Fire Department

MEMORANDUM

7 October 2009

Re: 645 Congress Street

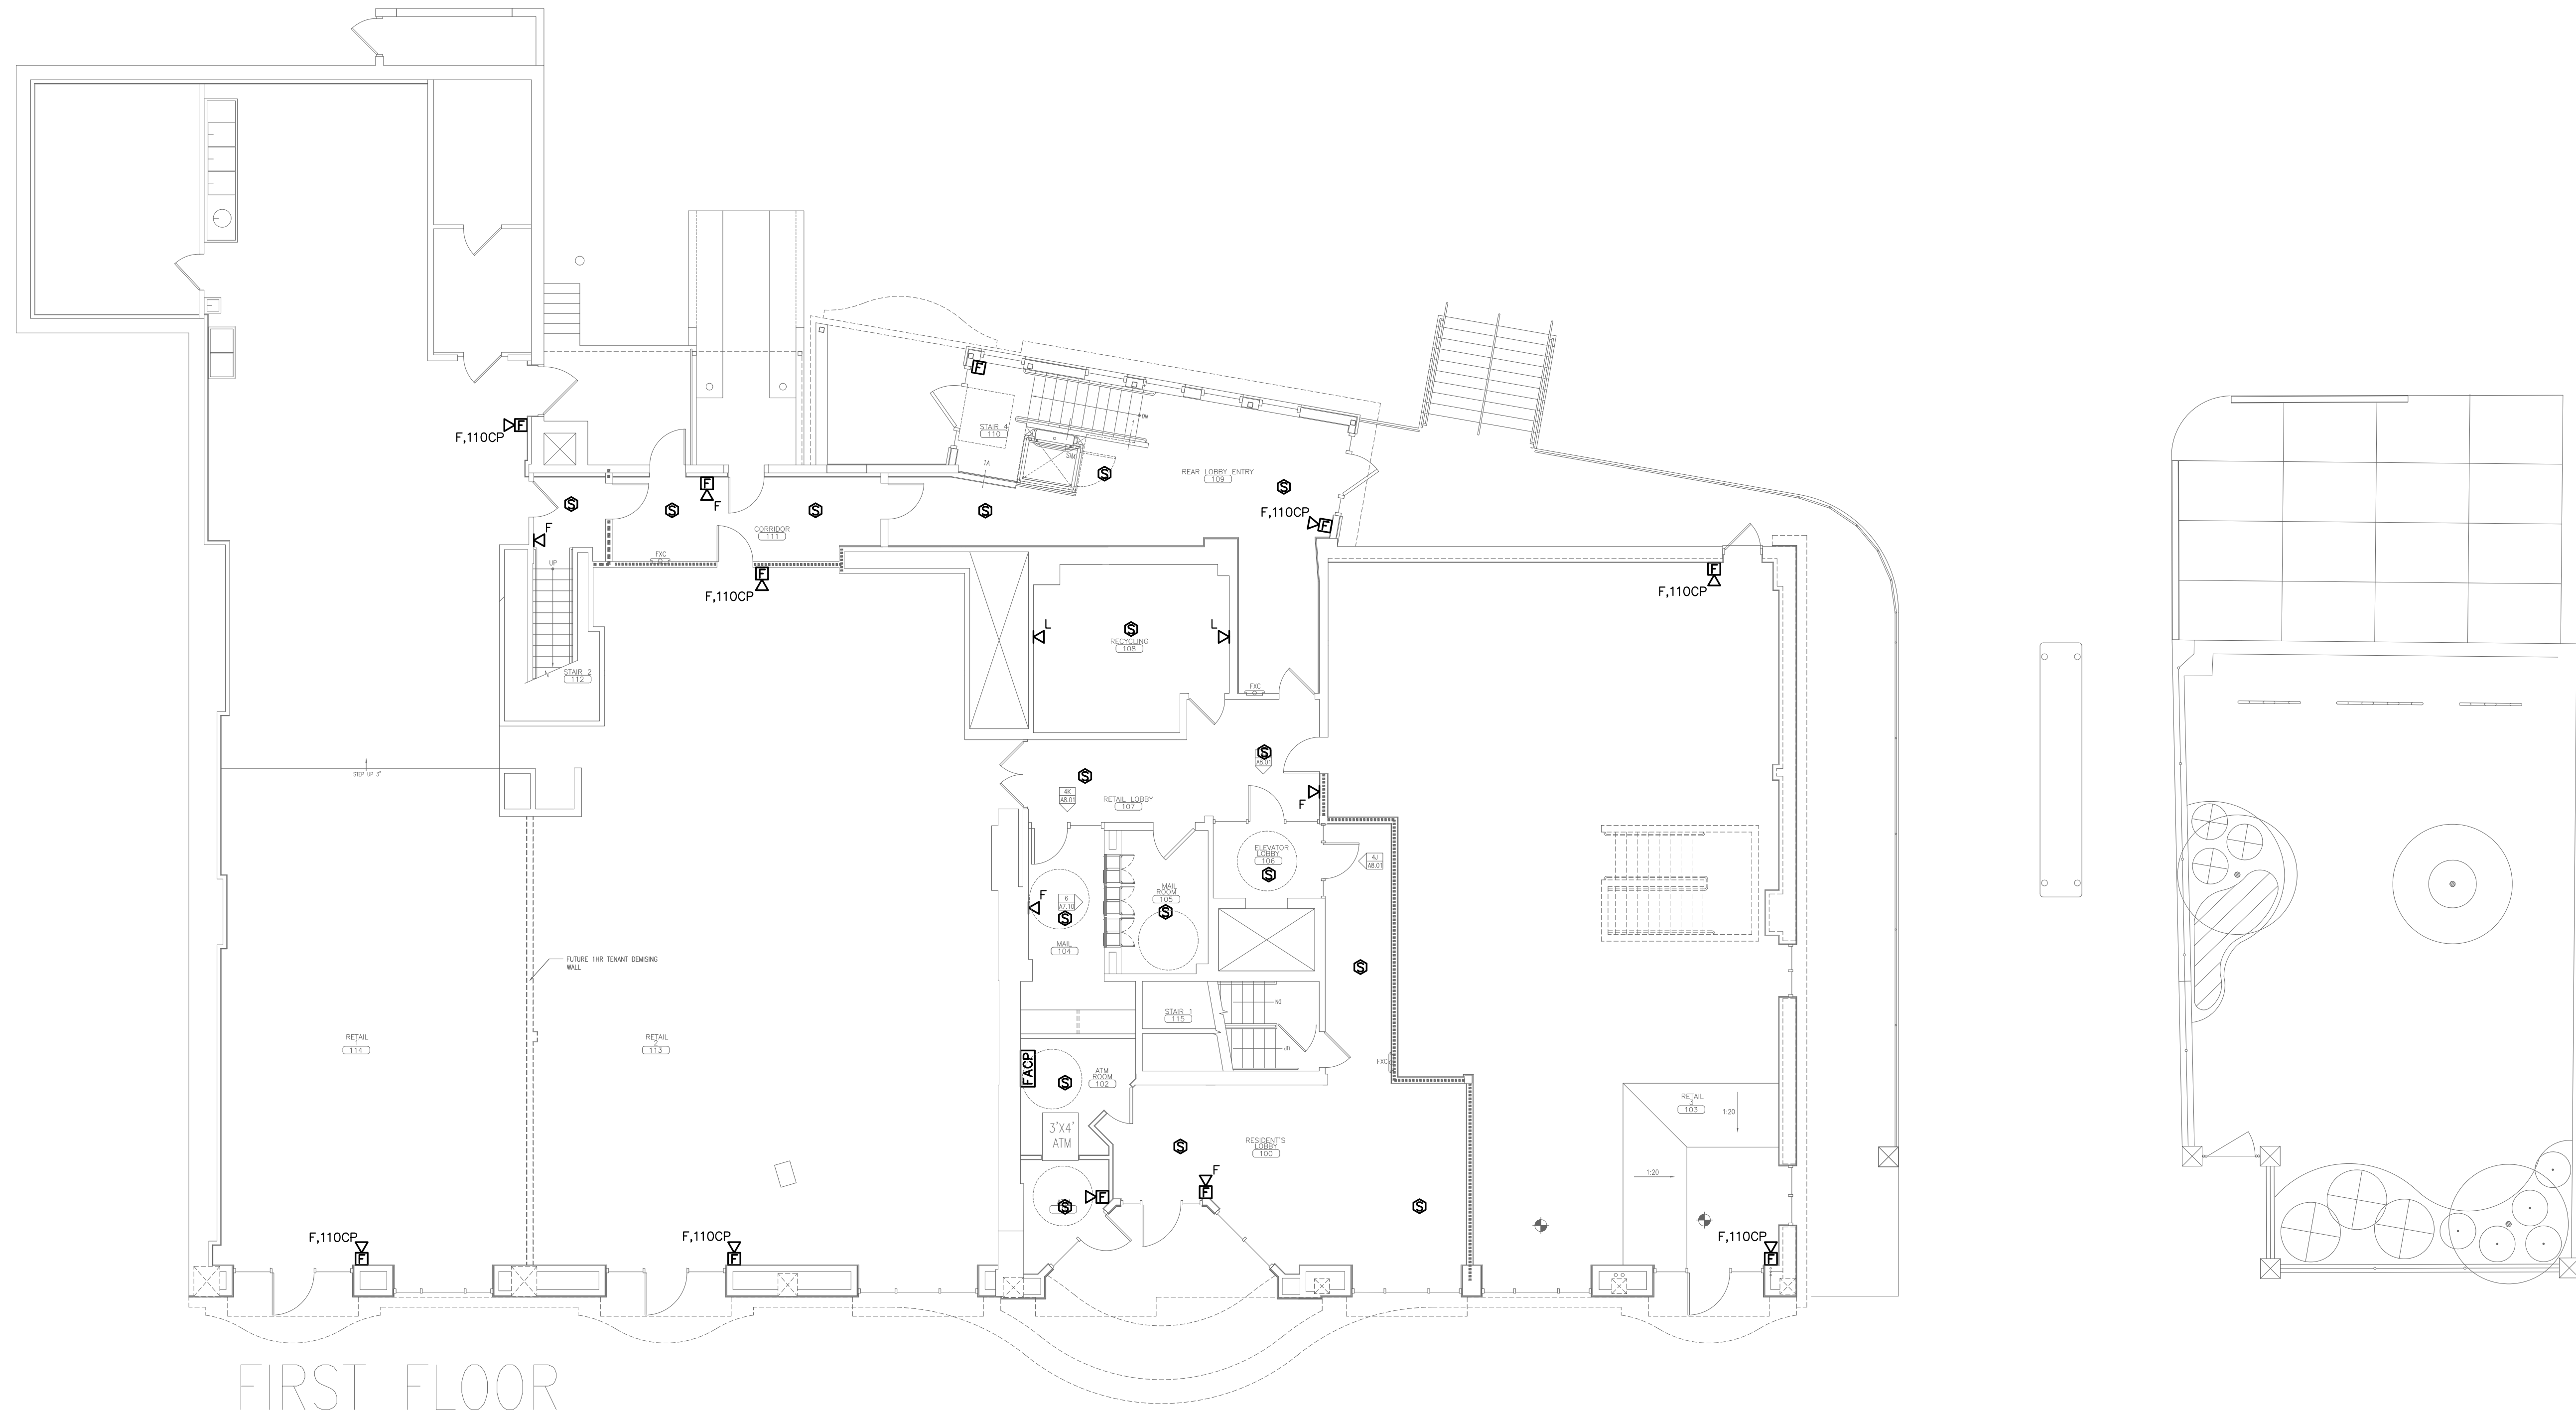
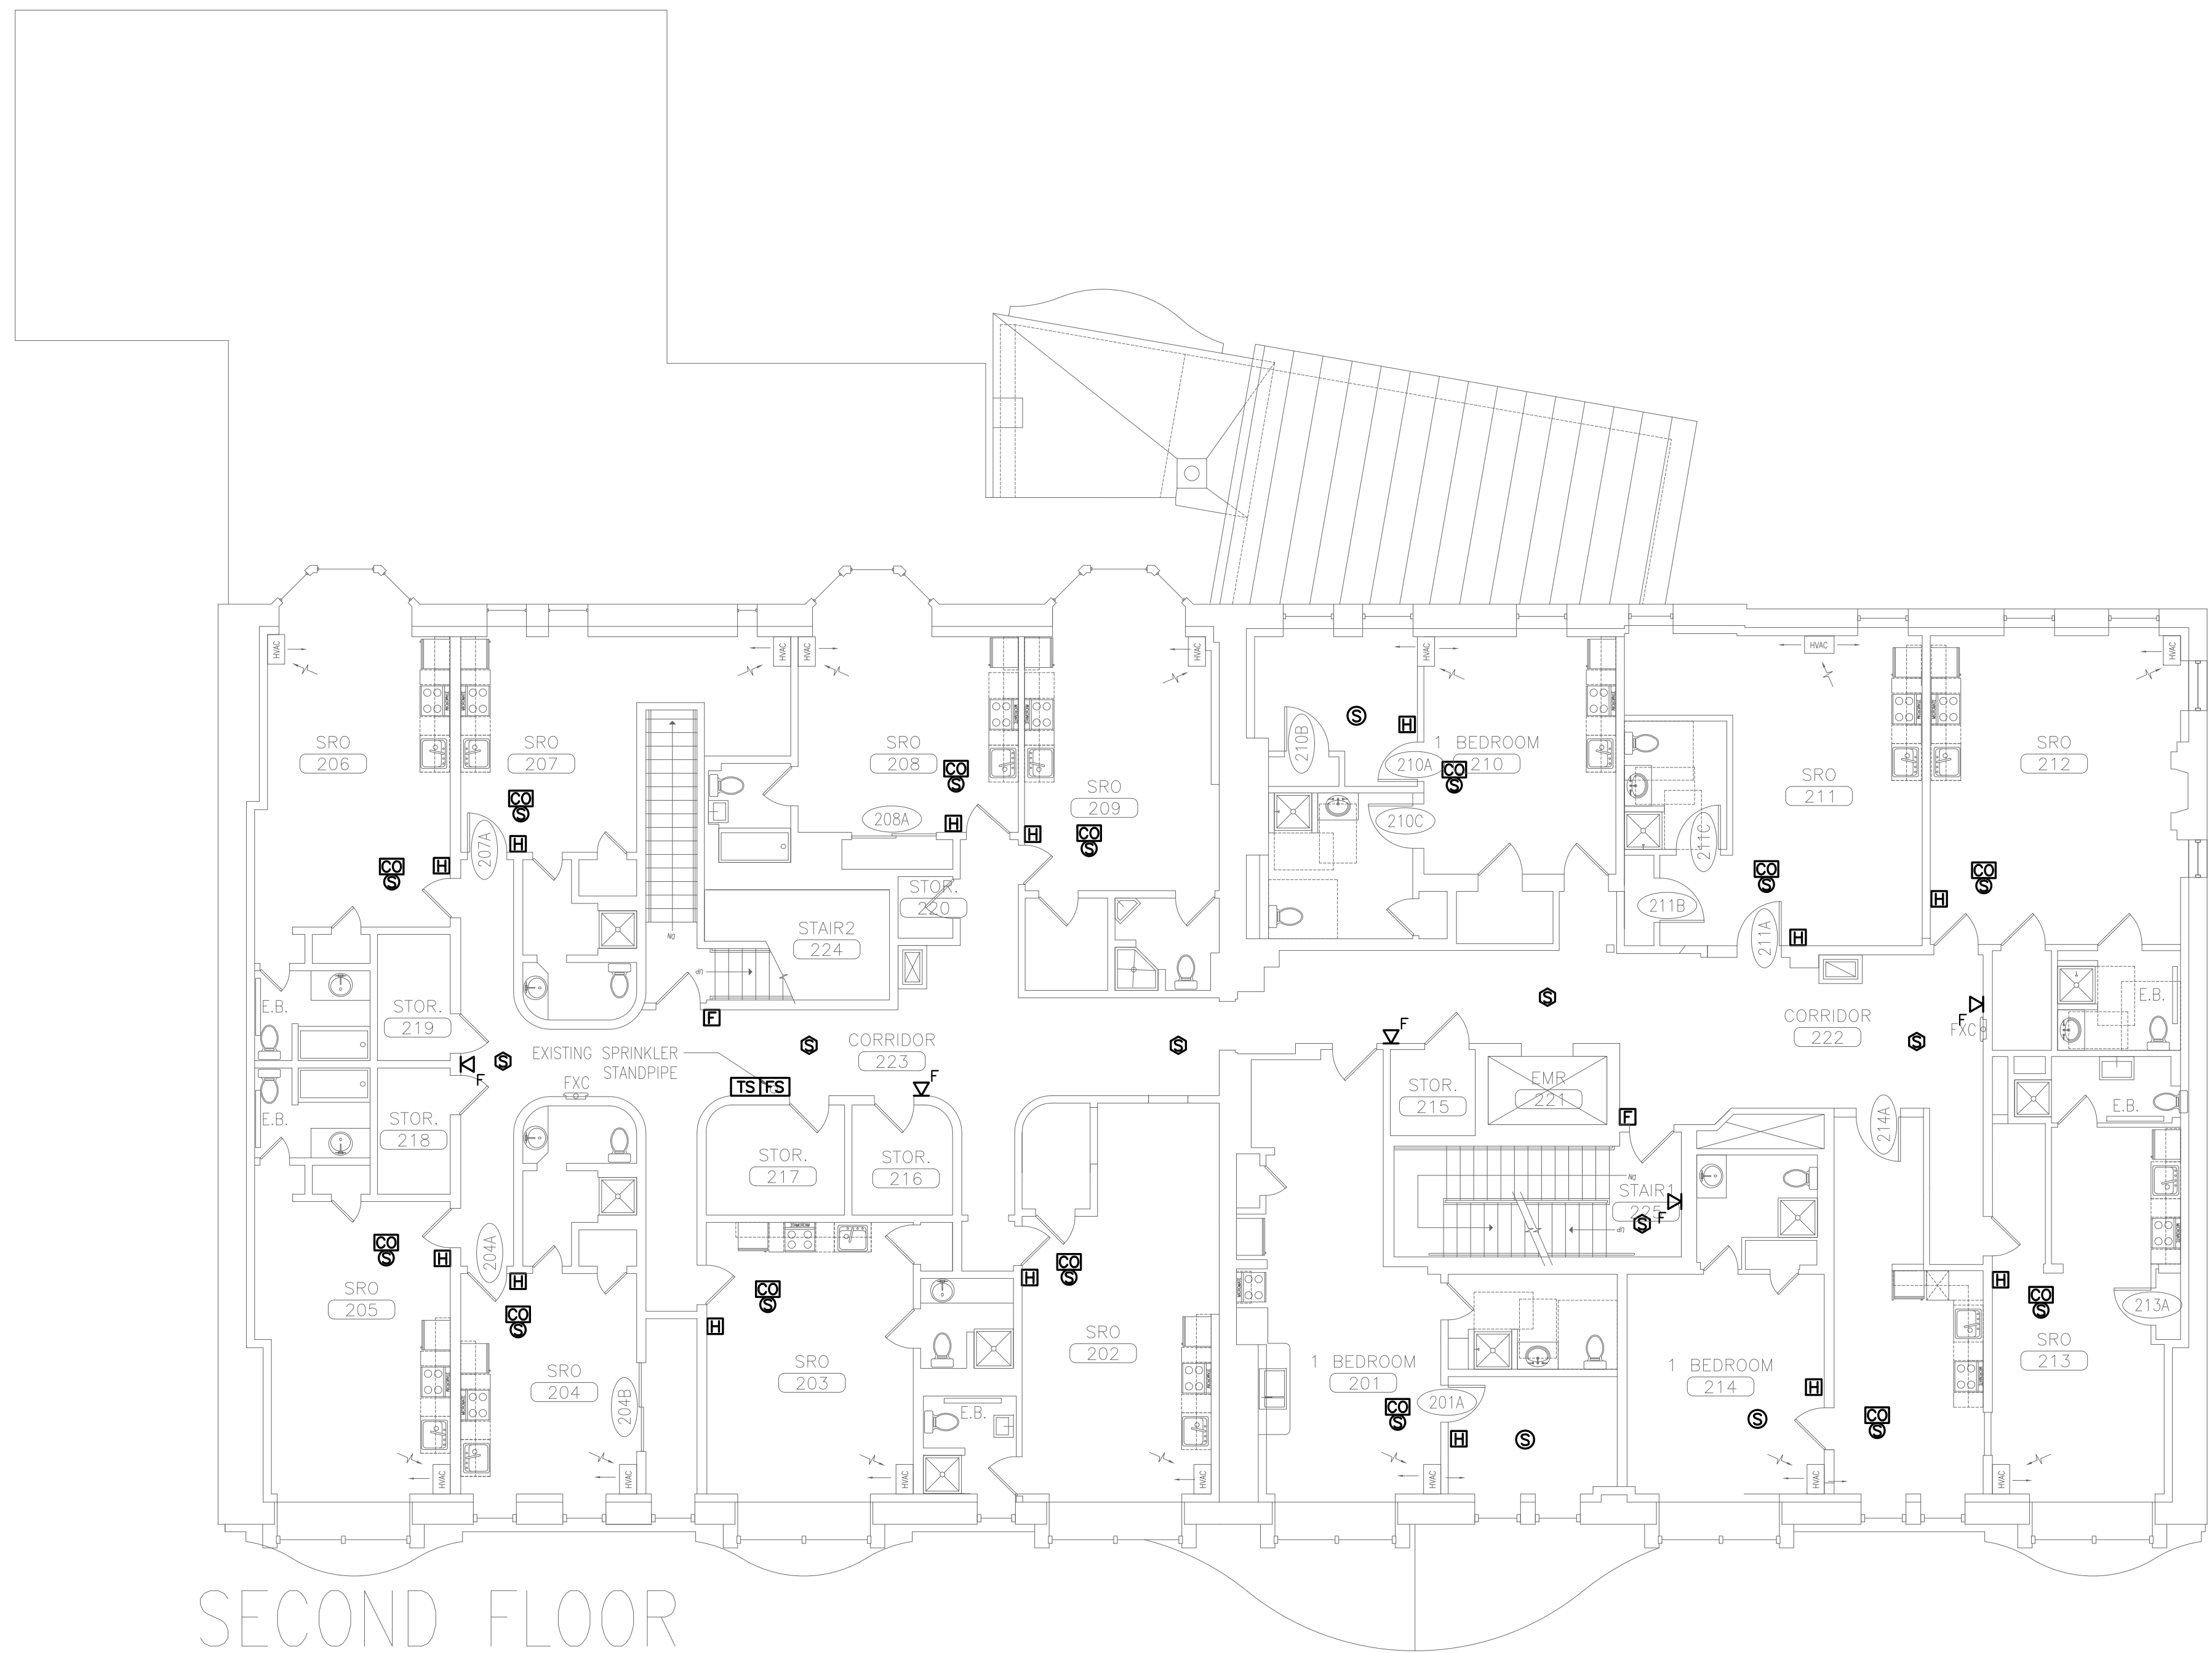
1. Because of the reuse of the existing building, certain existing fire alarm cable may be reused. All such cable shall be Fire Power Limited Plenum (FPLP).

2. In rooms where ceilings are sealed or the space above the ceiling is combustibile, all such cable shall comply with the National Fire Alarm Code, Article 760 of the National Electrical Code (NEC) and current City Code.

3. Where wiring is added or replaced, it shall comply with the National Fire Alarm Code, Article 760 of the National Electrical Code (NEC), and current City Code.

4. It must be verified there is two notification circuits on each floor, providing that every other notification appliance is on a different circuit.
5. An inspection of all fire alarm cables shall be performed prior to any close-in.
